R/165/17/HH

61, Tennyson Avenue,

I am writing to express my objection to the size, layout and proximity to my property, of the above extension that has been erected at the rear of 61, Tennyson Avenue.

drawing
Site/Block Plan and Roof Plan
As Proposed

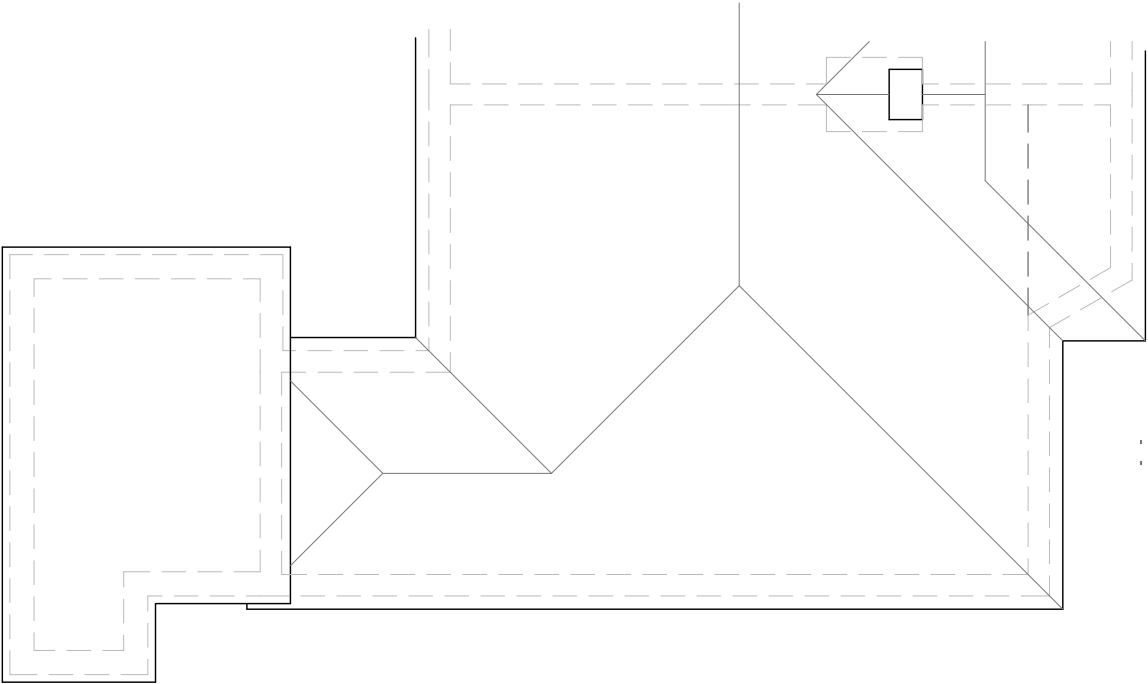
4/ The Plans submitted by RDV a Design, have conveniently omitted the boundary line between myself and the property in question, but the full boundary has been drawn on the other side. Without reference to the location plans, it would not be apparent that the fence line moves across into the garden of no.61, dramatically reducing the distance of the build from my property, in fact, this possibly moves it to within 1m of the fence.

South Sectional Elevation: Scale 1:100

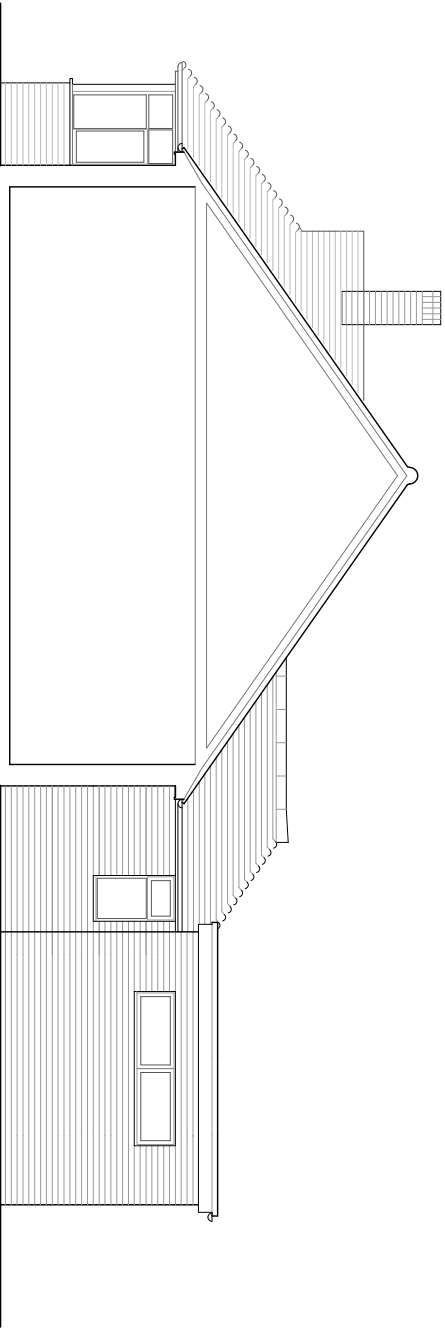
5/ The drawing of the South Sectional Elevation: Scale 1:100, shows the window in the extension at the same height as the original building windows. This is not the case, it is in fact higher.
